Subject: 66 ANCTON WAY M/143/18/PL

Here we have an application for a simple replacement dwelling in place of a non-traditional construction, asbestos filled dwelling that was uninhabitable. We have had 3 case officers on the application over the past 30 weeks and it has now reverted back to Richard Castro-Parker [RCP]. We received a VM yesterday, stating that RCP was concerned with the mass and siting of the proposal. Also he had concerns that the proposal extends 3.0m past the neighbour on the east [68?]. This is indeed itself a small non-traditional dwelling full of asbestos similar to the one that stood on this plot, which no doubt will be also raised to the ground and redeveloped. The dwelling is no further into the site than any others along Ancton Way as seen on the site location plan. We feel extremely disappointed with RCP comments, although RCP does not actually say he is recommending refusal, as he cites he needs to speak with you first. Throughout this application the dialogue has almost been non-existent, but when we did manage to speak with a case officer [Stuart Corbey] the proposal received a positive response subject to Environmental Agency approval. Even the Paris

Block Plan - Scale 1:500

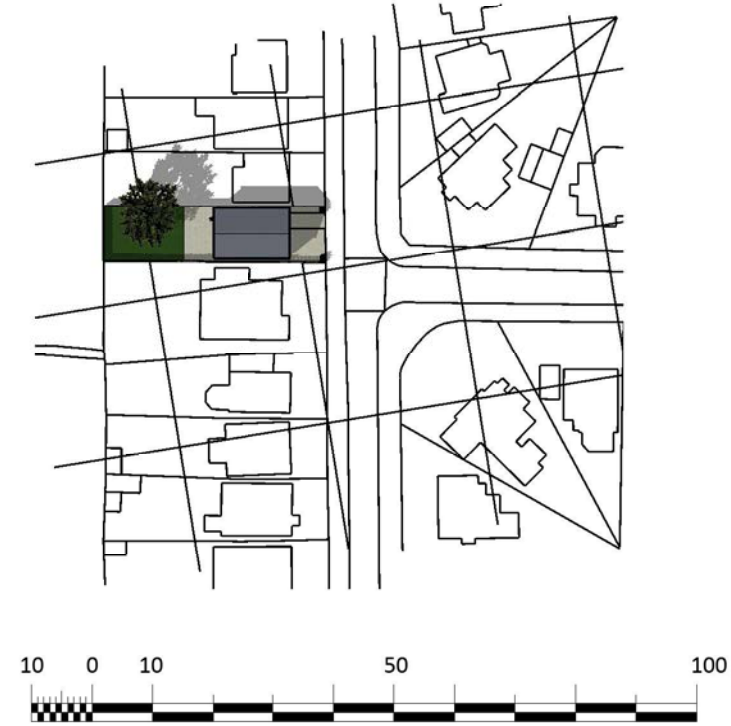
I did go through this application with Richard this morning and I share his views. We have no objection to the design of the building as it applies to the character and appearance of the area. However, the rear projection hard up against the boundary with number 68 will mean that for 3 metres of their rear garden they will face a very unneighbourly outlook – nearly 6 metres of a solid wall plus a ridged sloping roof. My suggestion would be that you withdraw the application and resubmit with a dwelling that addresses this objection. If you choose this option I am more than happy to look at some sketches and provide an informal view before you formally resubmit.

We are not convinced by the objection to the boundary of 68 and the 'unneighbourly outlook'. We have attached a sketch which shows we are within the prescribed 45 degree rule. The proposal in fact sits almost entirely within the existing plot as shown on the OS plan. We note a recent planning approval at 72 ancton way which looks longer than the proposal at 66, runs past at least one of the neighbours by at least 3.0m and is sat within the 45 degree line.
